Application for a non-material amendment following a grant of planning permission.

Erection of 1 no. dwelling and formation of new vehicular access.

Reference number: BN/24/20

To incorporate an integral garage into the building and other alterations to the fenestration arising from the rearrangement of the internal accommodation

PROPOSED PLANS
Dwg. No. 03

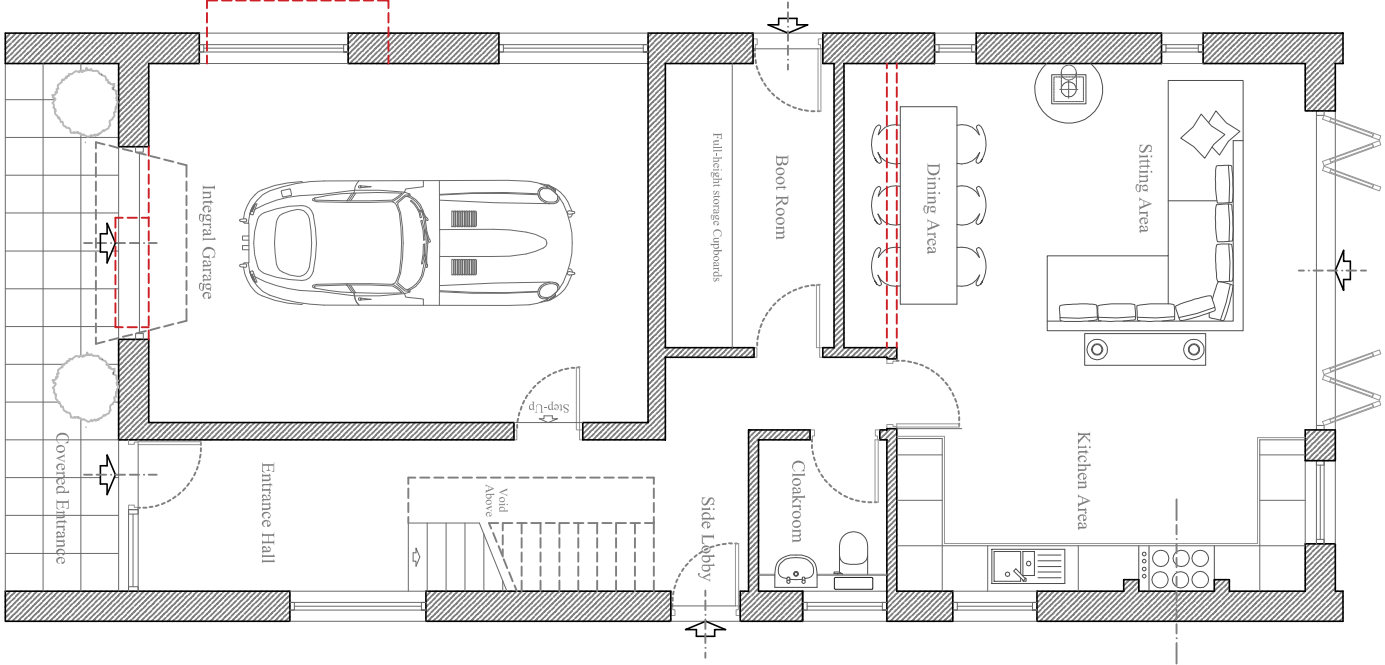
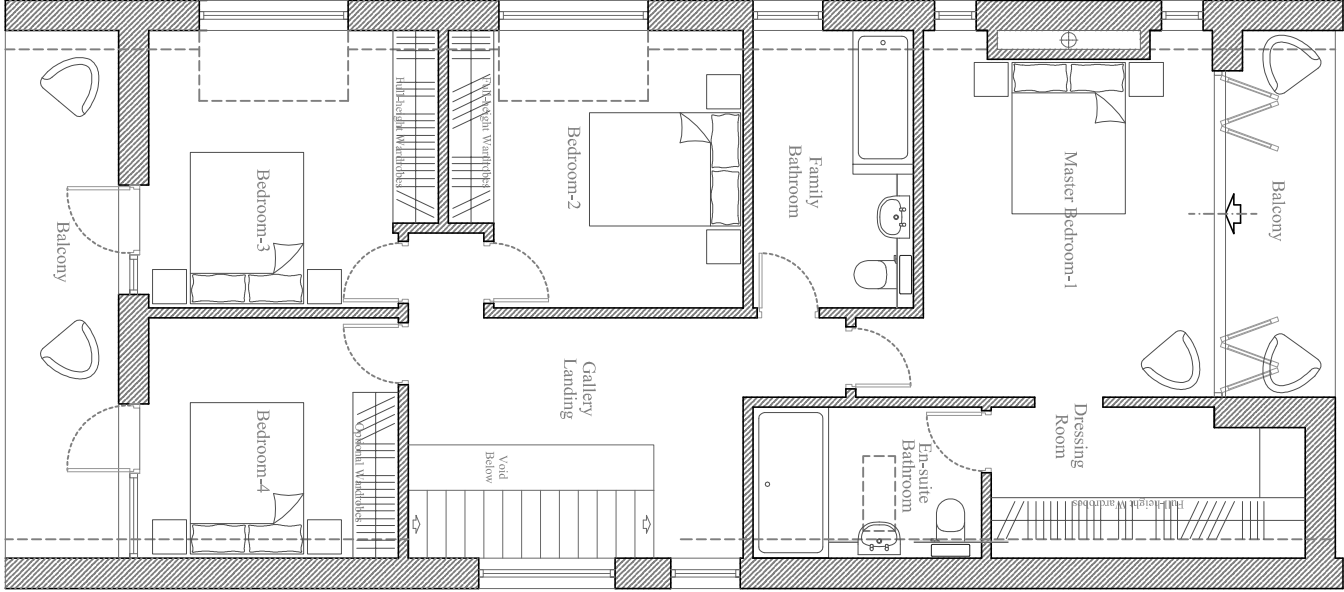
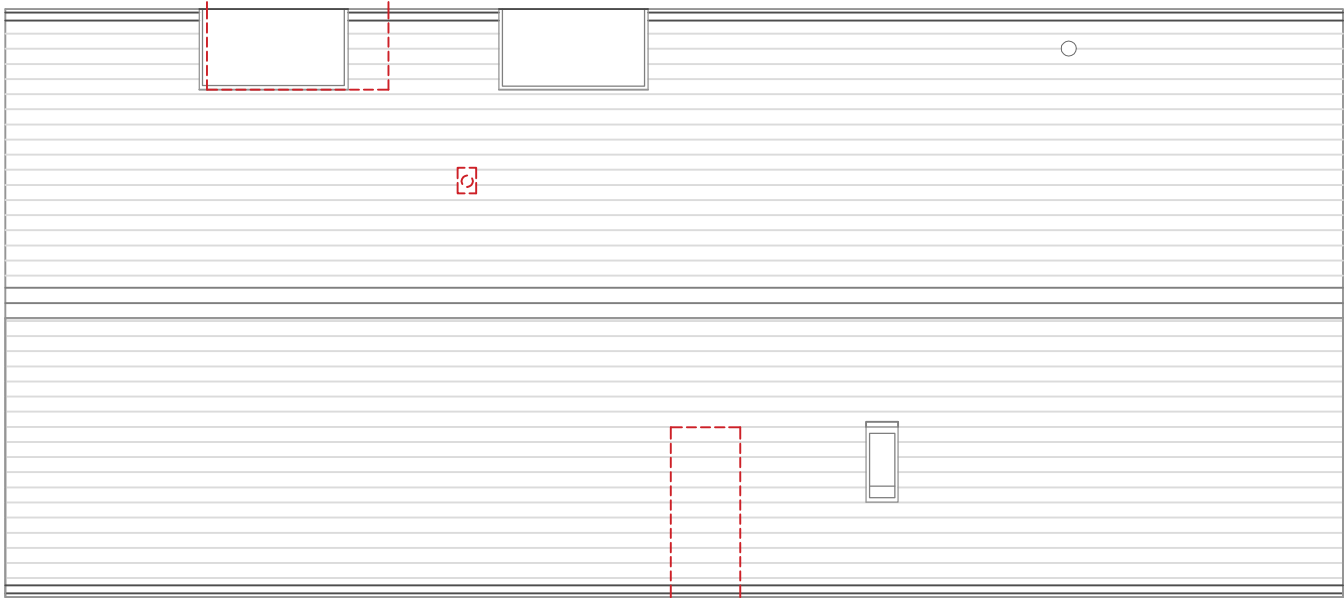
To incorporate an integral garage

Proposed Plans (03) Rev B
Proposed Elevations (04) Rev B
